Addendum No. 1

RE: Contract # C204564

43 SECTIONS OF SECONDARY ROADS.

November 17, 2020 Letting

TYPICAL SECTION NO. 3

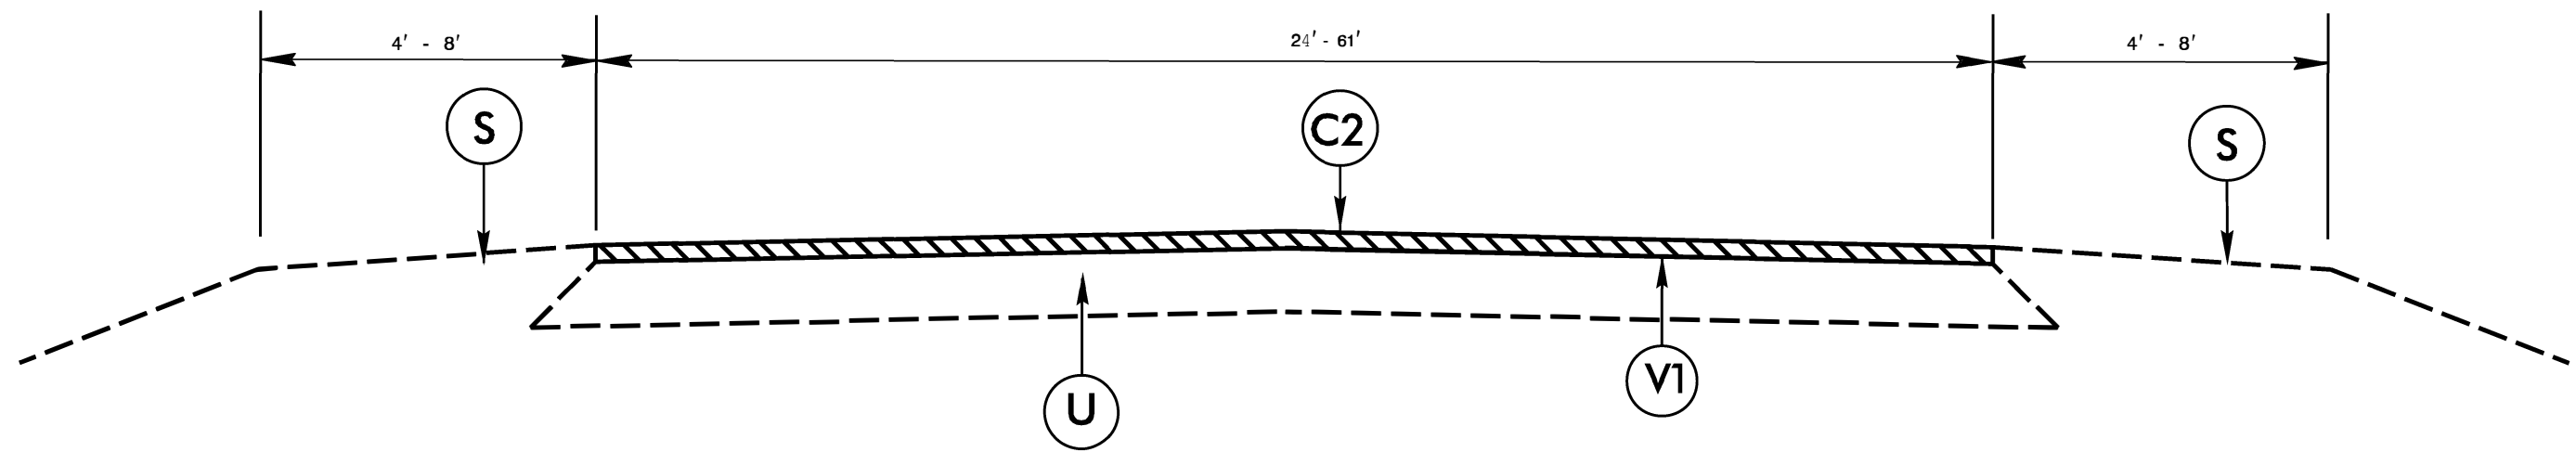
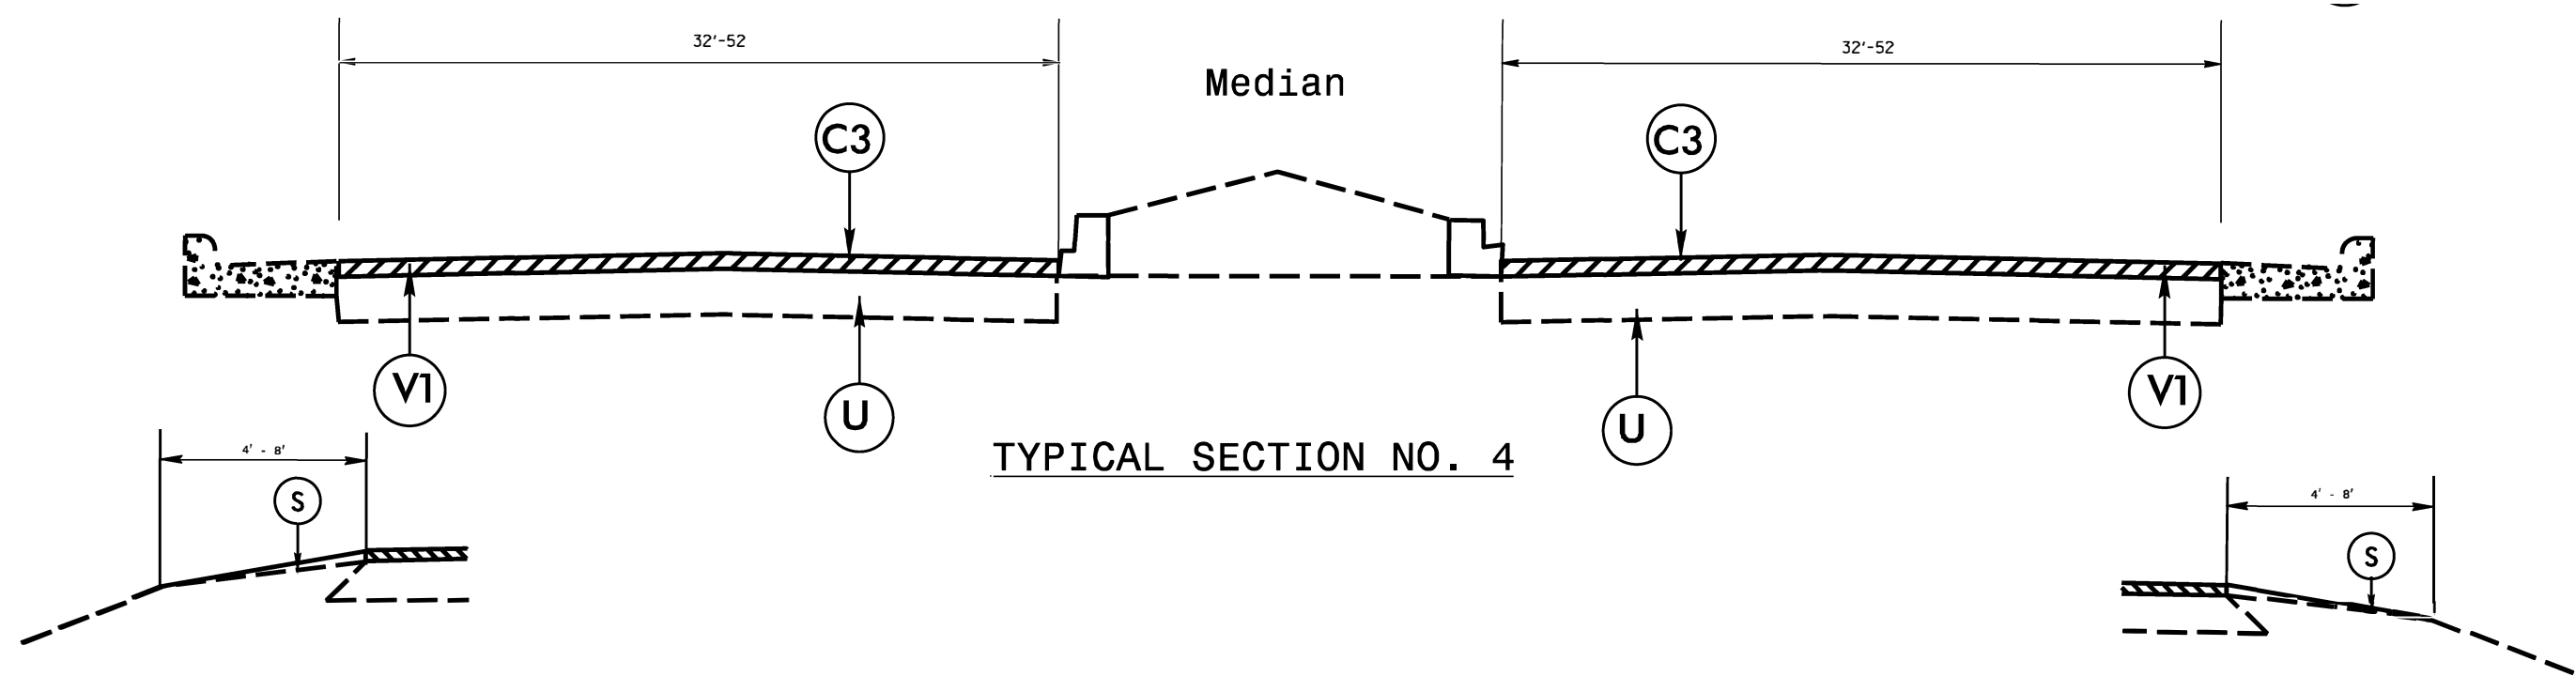
Sheet No.	Revision
14	Curb and Gutter cutouts for Typical Section #3 were removed
